OPEN FLOOR HEARING #1 – WRITTEN SUBMISSION 26/11/2026

Verbal evidence given on Thursday 6th November 2025

My name is Nicholas Bridges. I am a chartered architect specialising in heritage and planning, living in Orford. My mother was a founding member of the Alde and Ore Association. My Relevant Representation number is 3944. I have 3 points on heritage and landscape impacts, and the importance of the ExA recording its assessments without fear or favour.

Document Title: BARE EARTH ZONE OF THEORETICAL VISIBILITY - CONVERTER STATION SITE 1

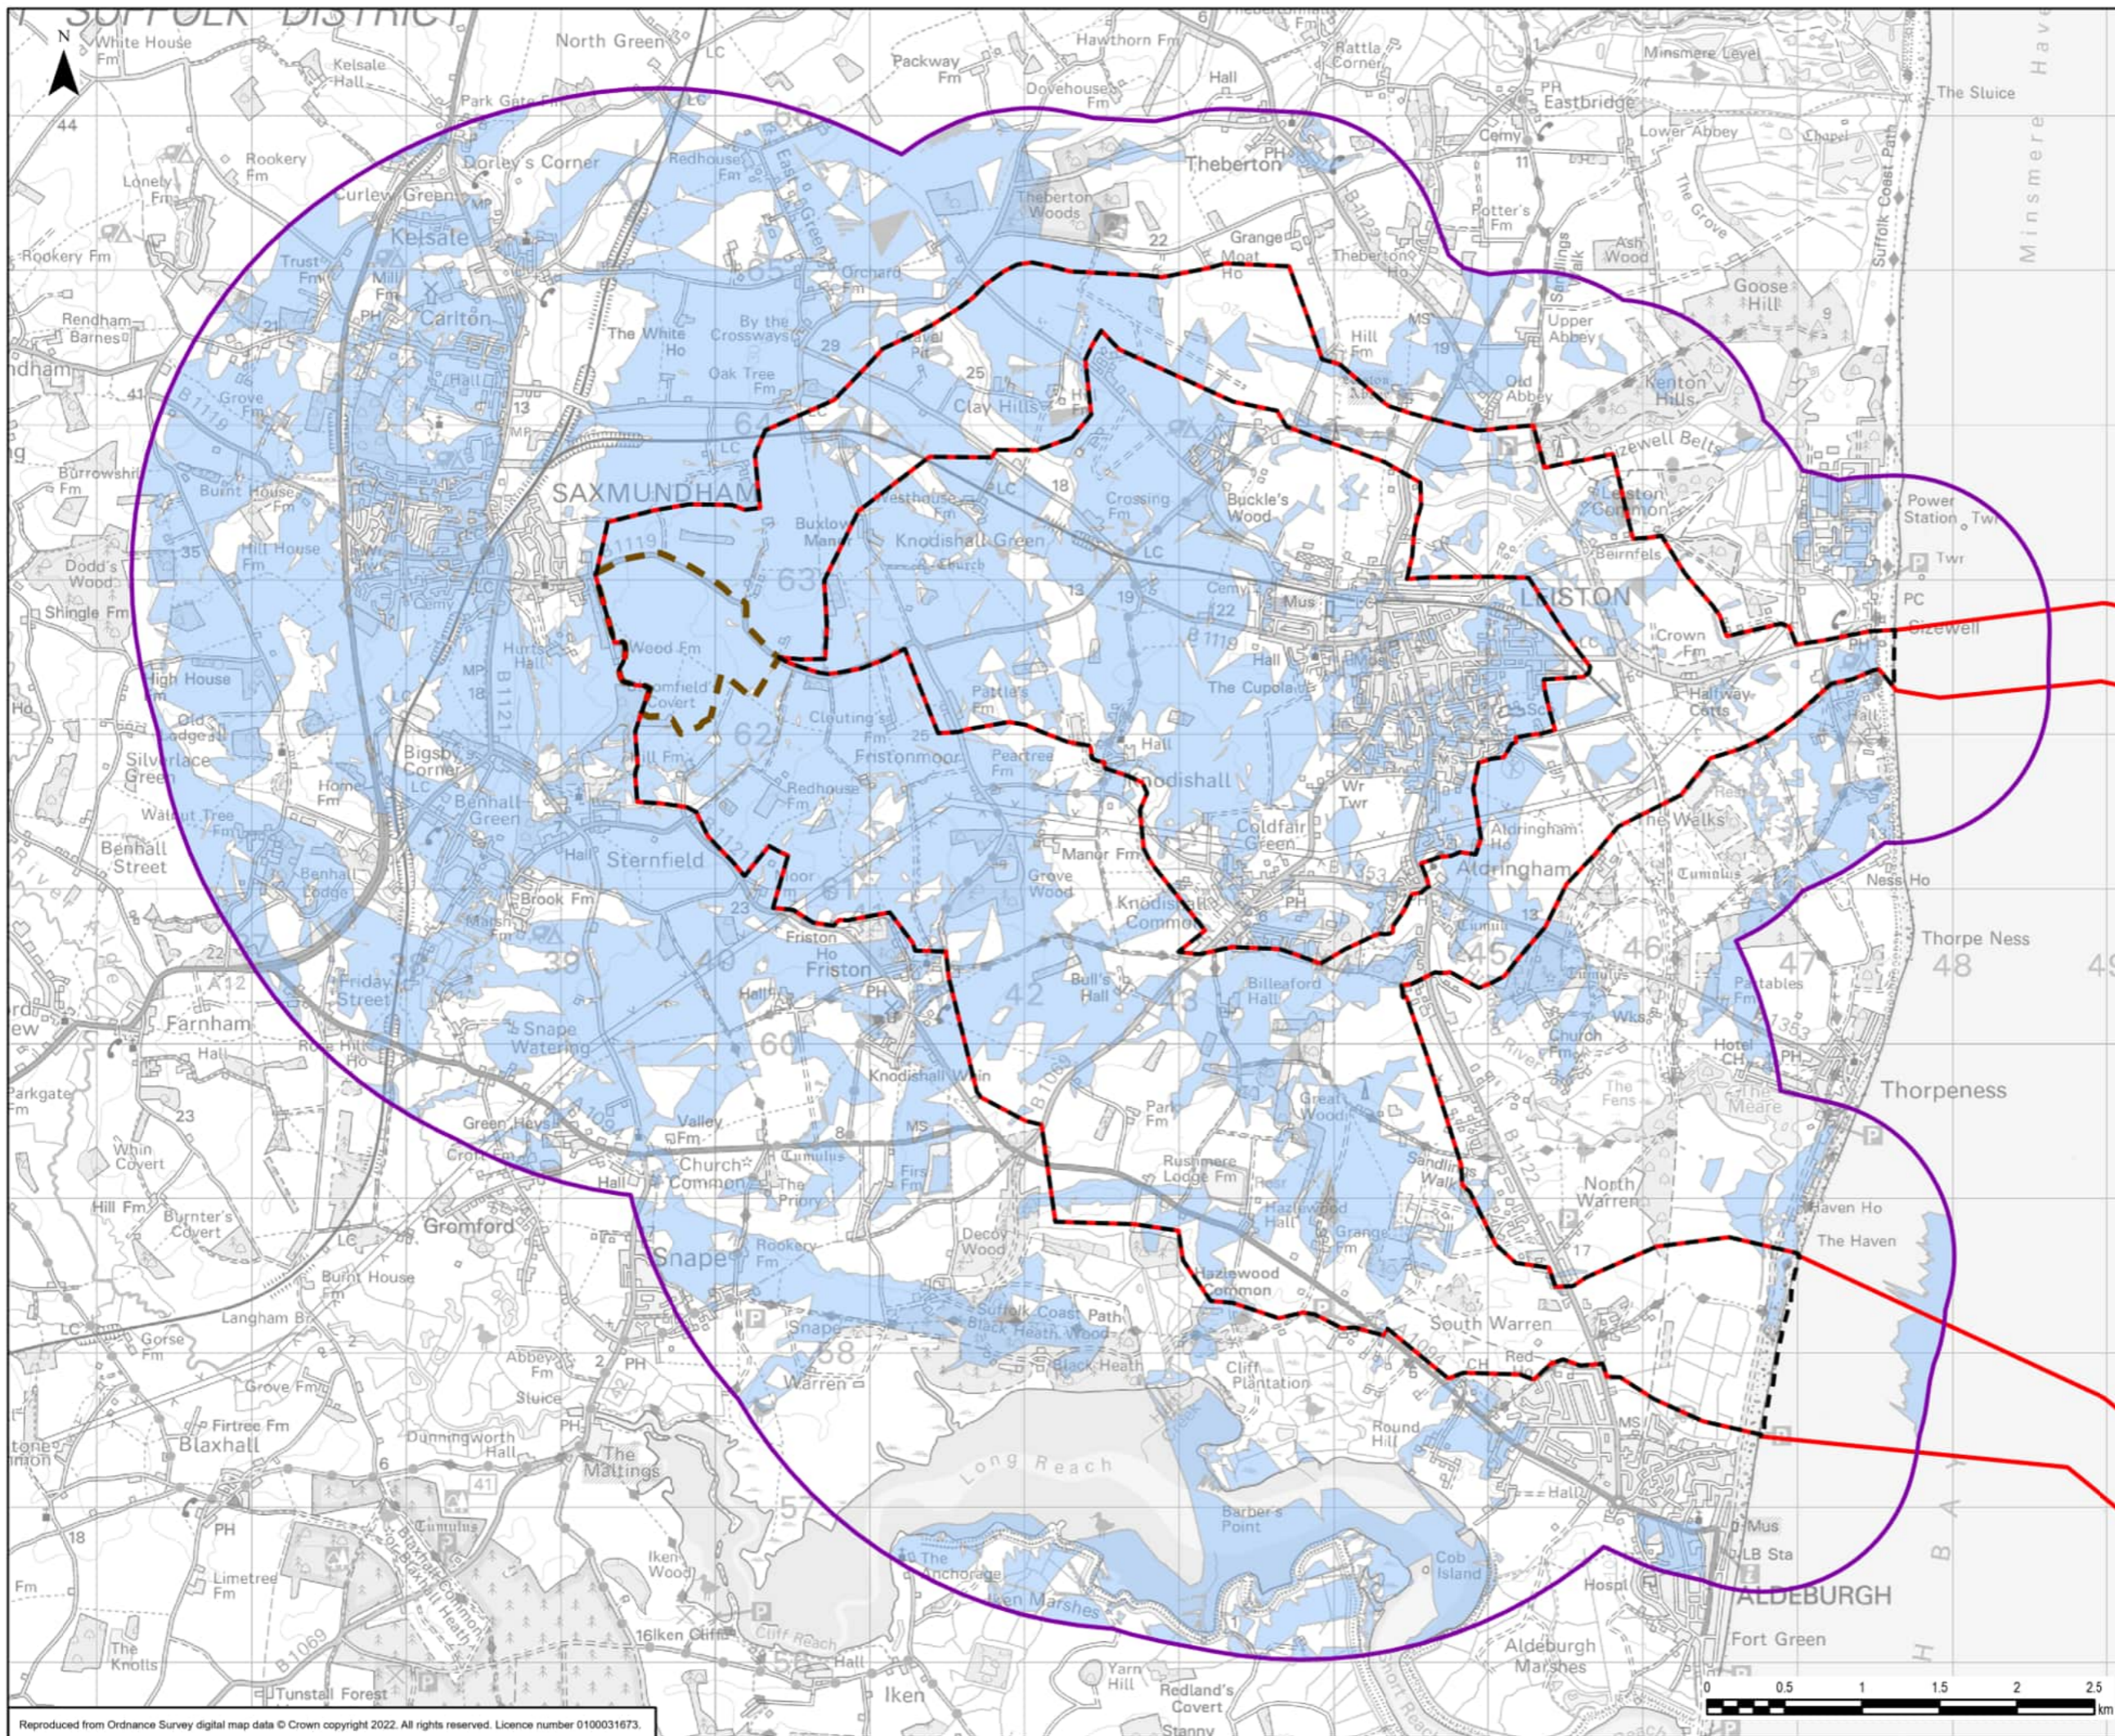
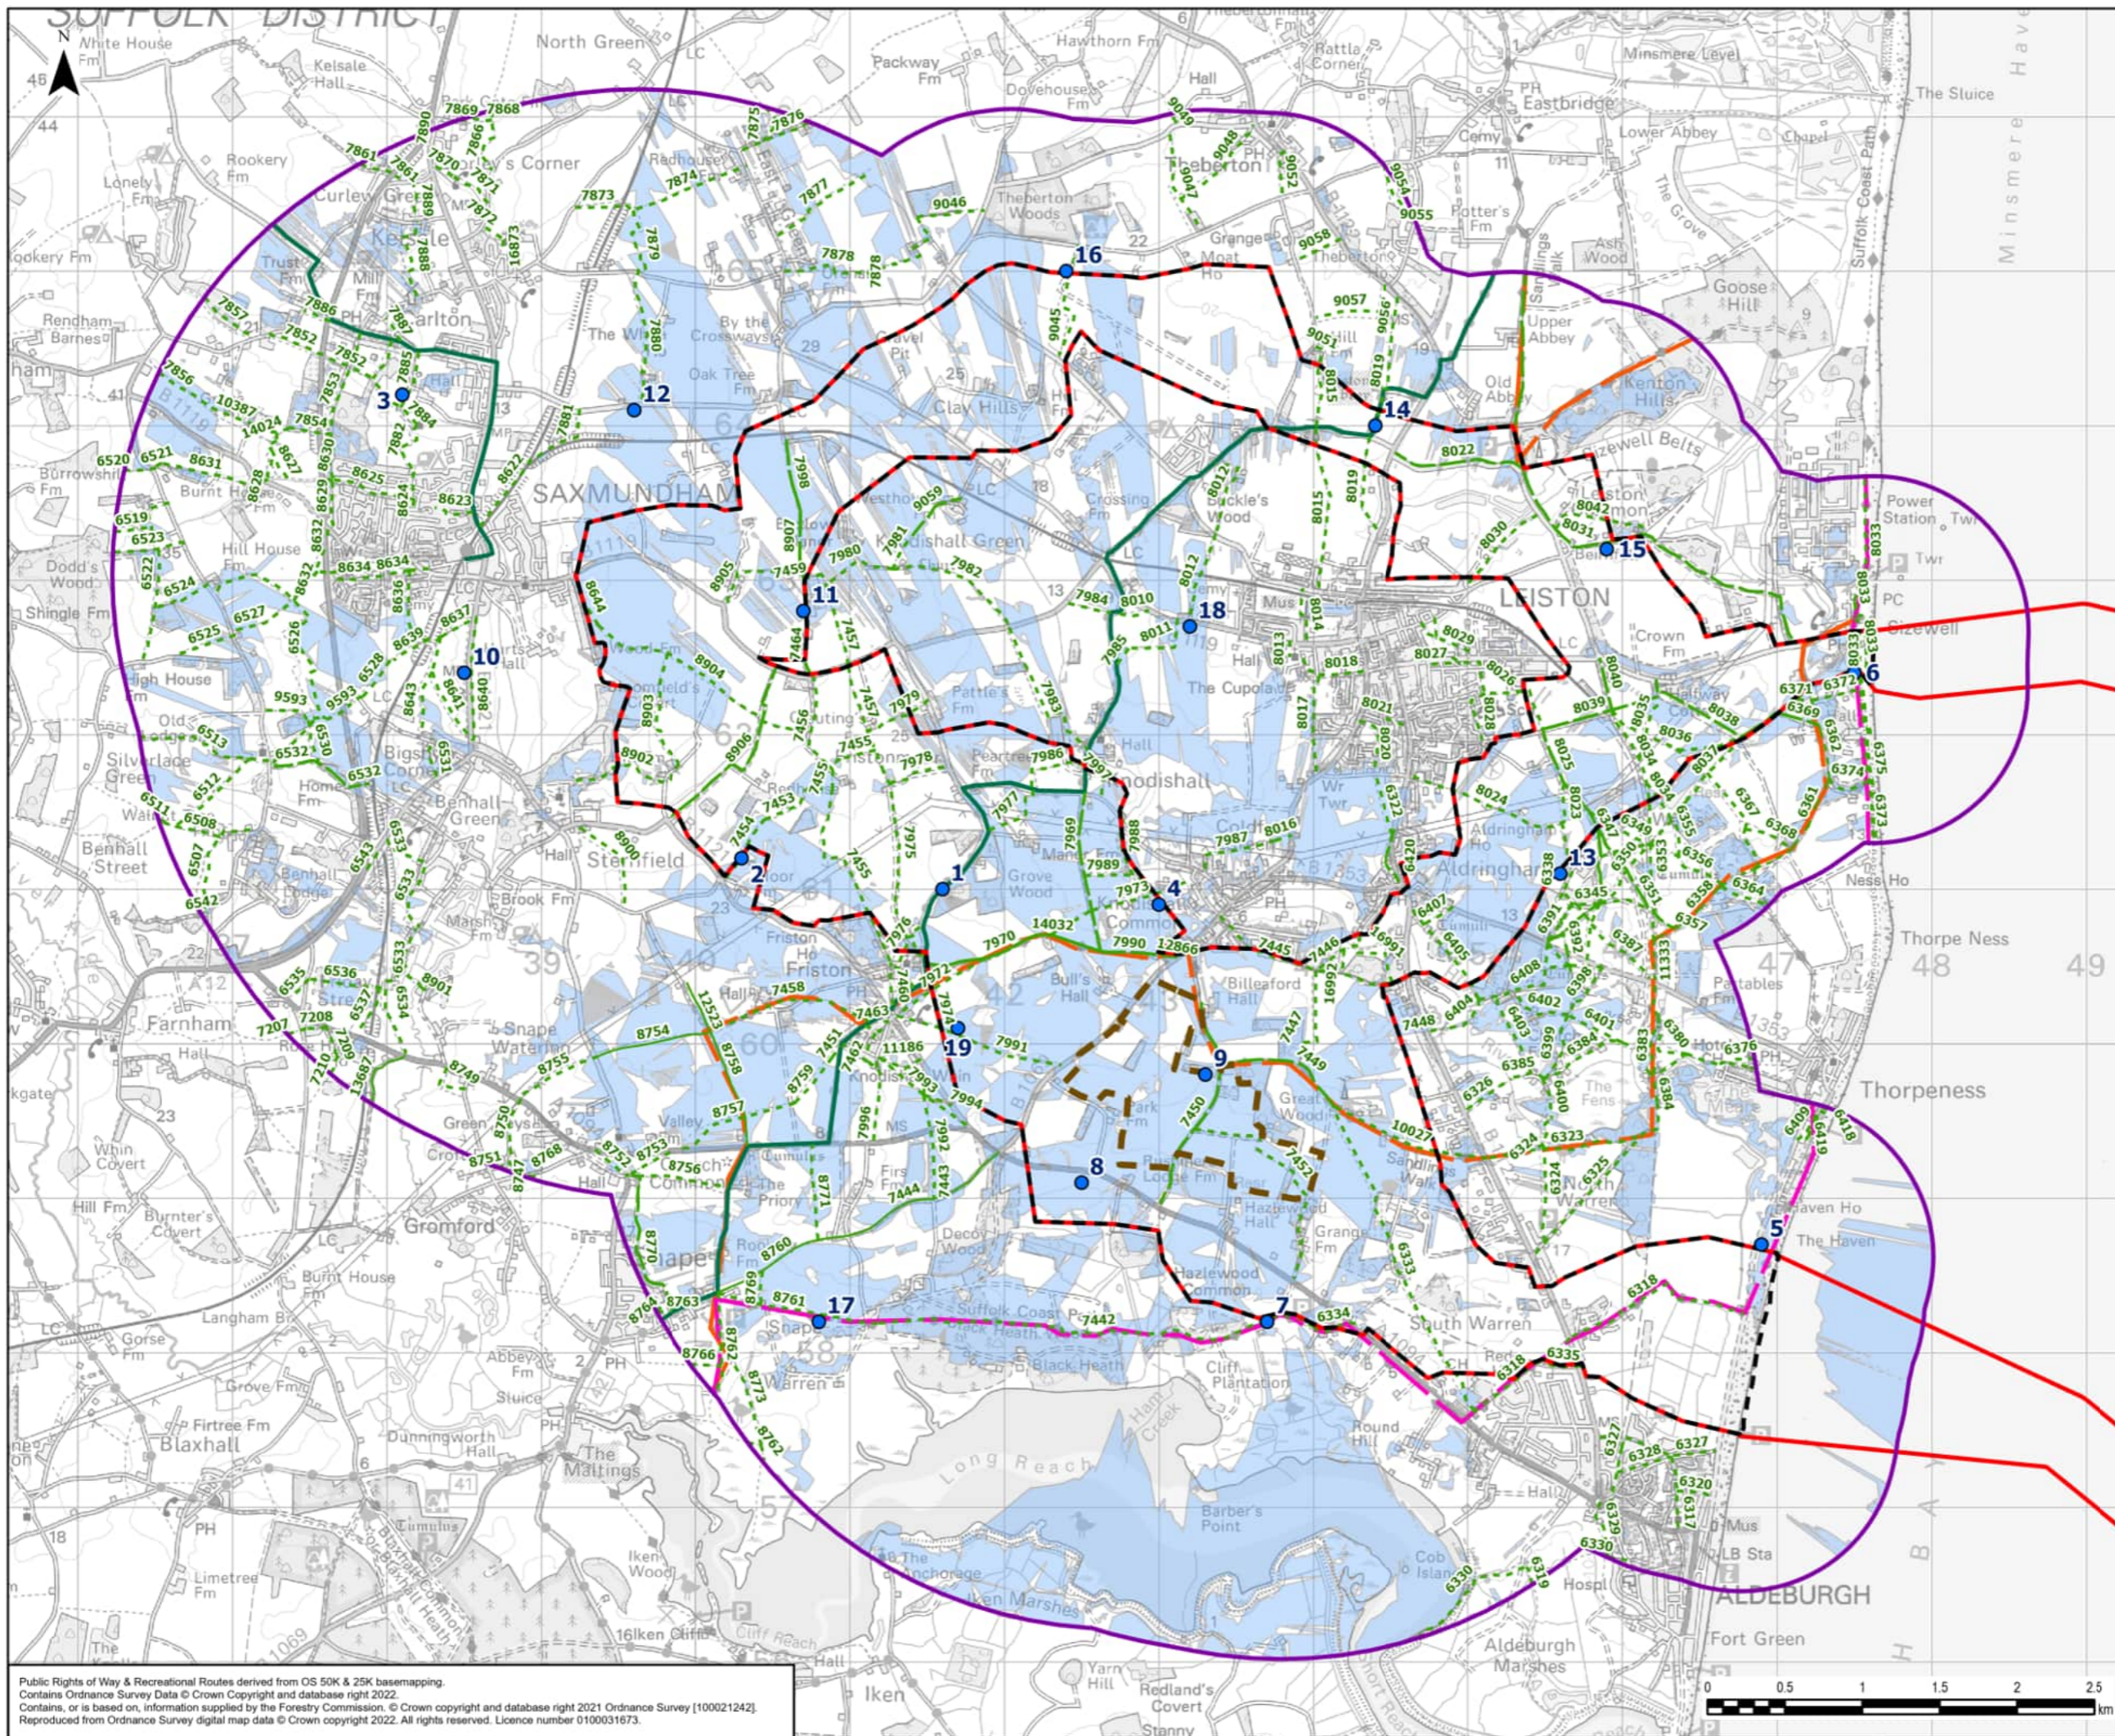
1 The LVIA's Area of Search was so small that it excluded the visibility of the Substation and converter station shown in the ZTV plans. These will be visible from the south side of the Alde Estuary, in the AONB, and within the settings of the listed St. Botolph's, Iken, and Martello Tower CC at Slaughden. Both have high national historical and architectural interest. Despite my request for NGET to submit their ZTV plan which already shows visibility of both the Saxmundham and Friston buildings at the south side of the Alde Estuary, they have not done so, nor explained why not. The lack of assessment on the effects on Landscape, Visual and Cultural Heritage ES topics is a major omission as the part of the estuary affected is inside the Suffolk Coasts and Heaths AONB and is covered by multiple natural designations.
